From: Martyn White
Sent: 09 April 2019 17:58
To: Planning.Responses
Subject: Y/15/19/HH

Y/15/19/HH

The application is for a rear single storey extension to a property which is located within the Yapton: Church Road/Main Road Conservation Area.

PROPOSED EXTENSION  
SAXON HOUSE MAIN ROAD YAPTON  
ARUNDEL WEST SUSSEX BN18 0ET

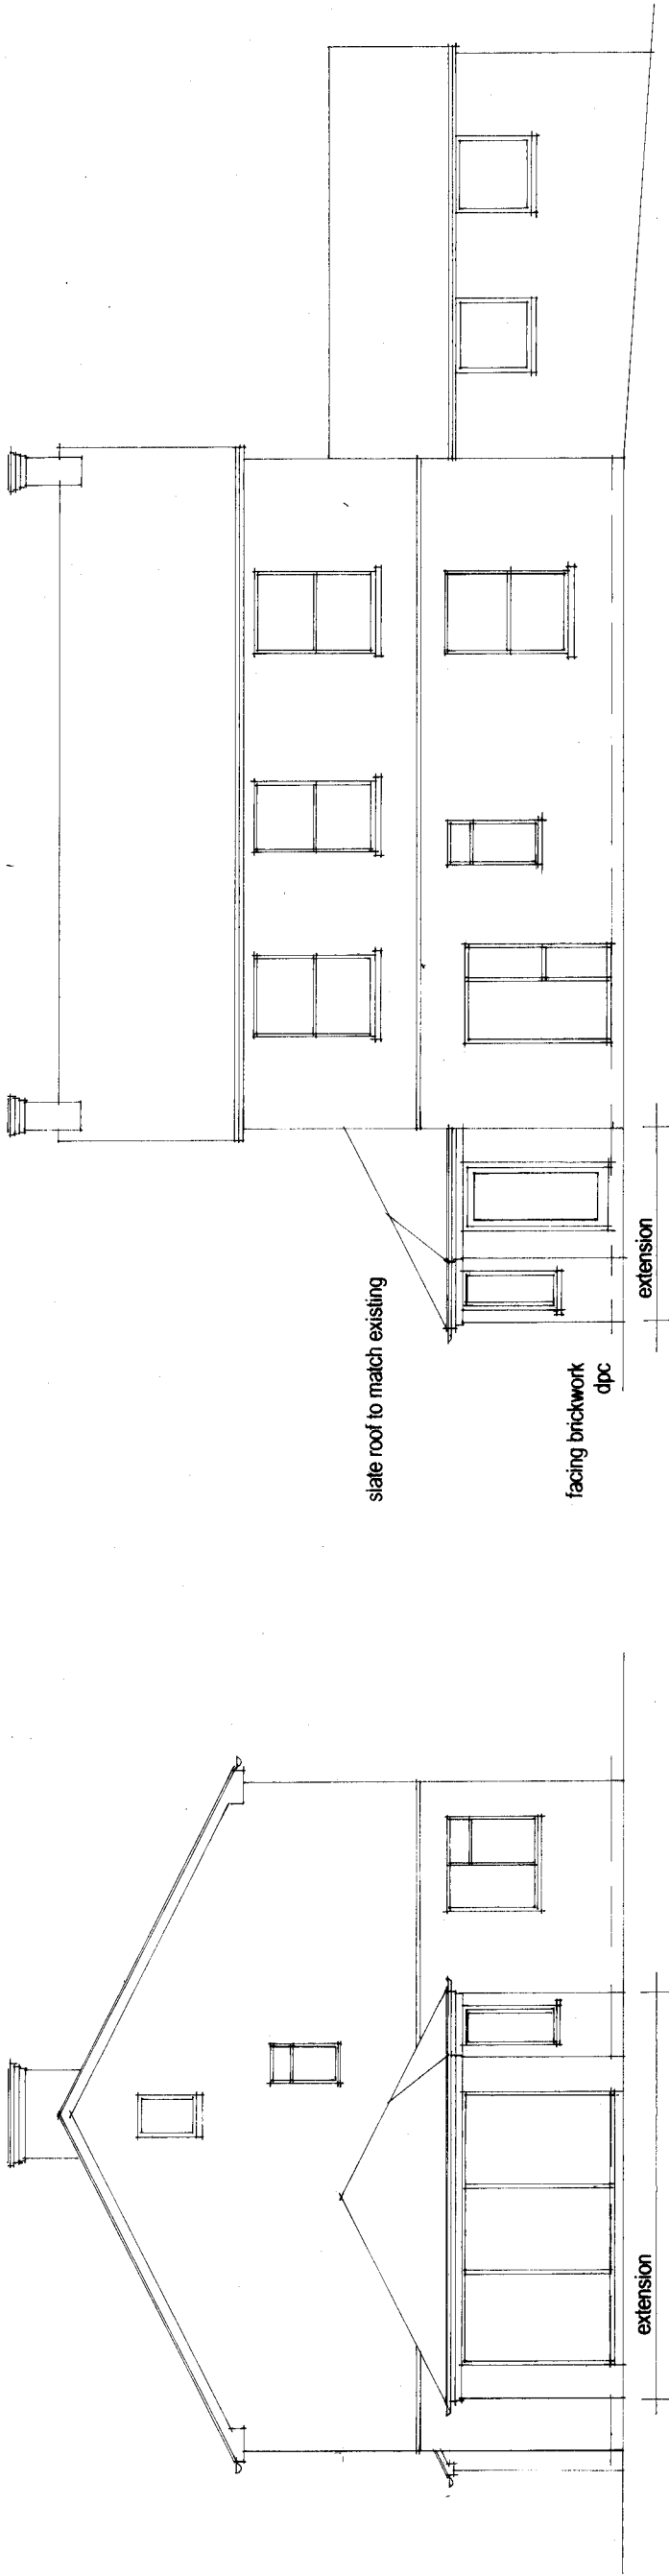
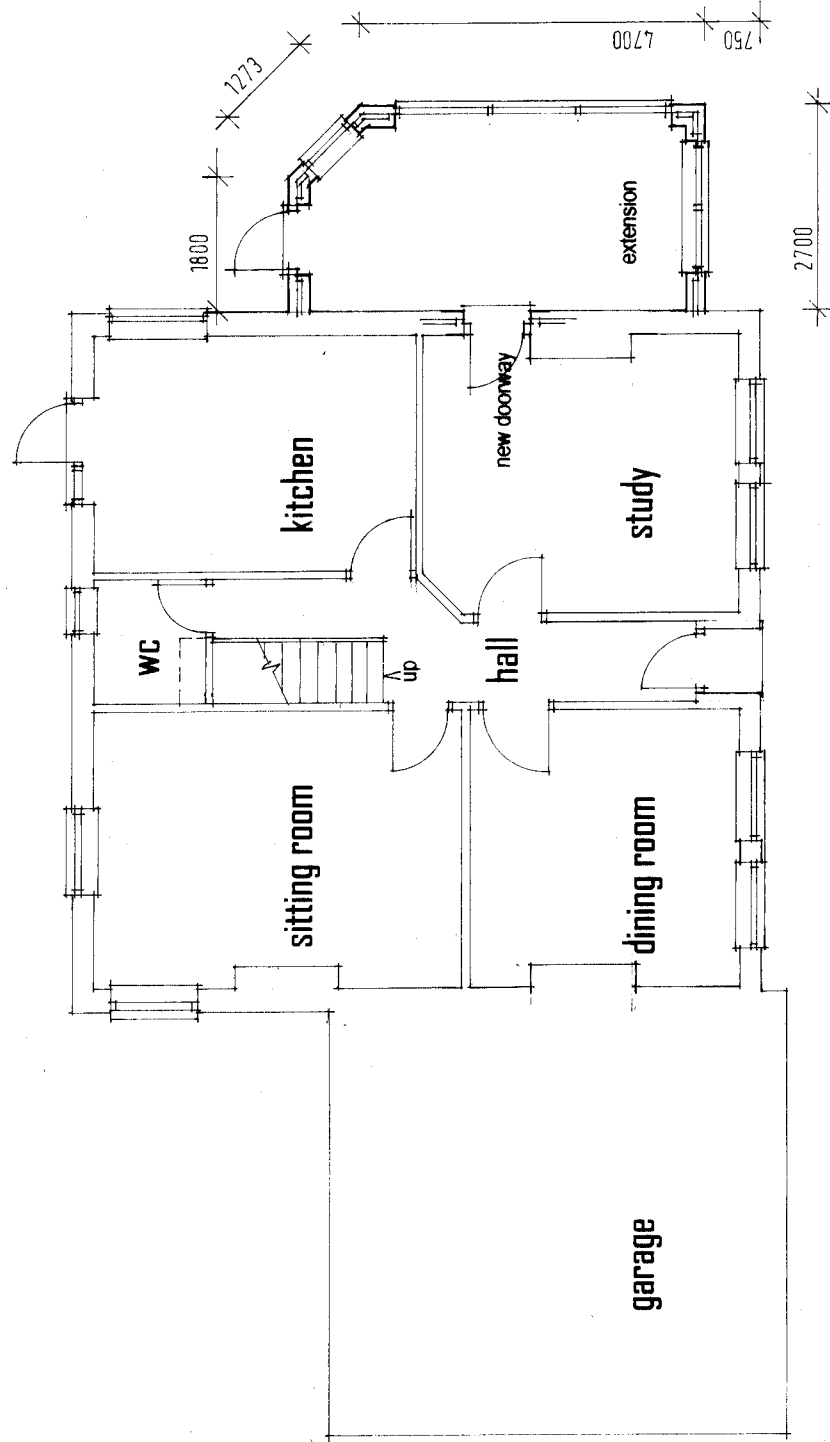
The proposed extension is small in scale, and will appear subservient to the host dwelling. Further, it will also not be visible from the public highway.

As a consequence, it is considered that the proposed extension will not harm the Character or appearance of the Conservation area.

Reference is made to the fact that the materials will match the existing, but it is recommended that a condition should be prepared which ensures that this occurs, if you are minded to approve the application.
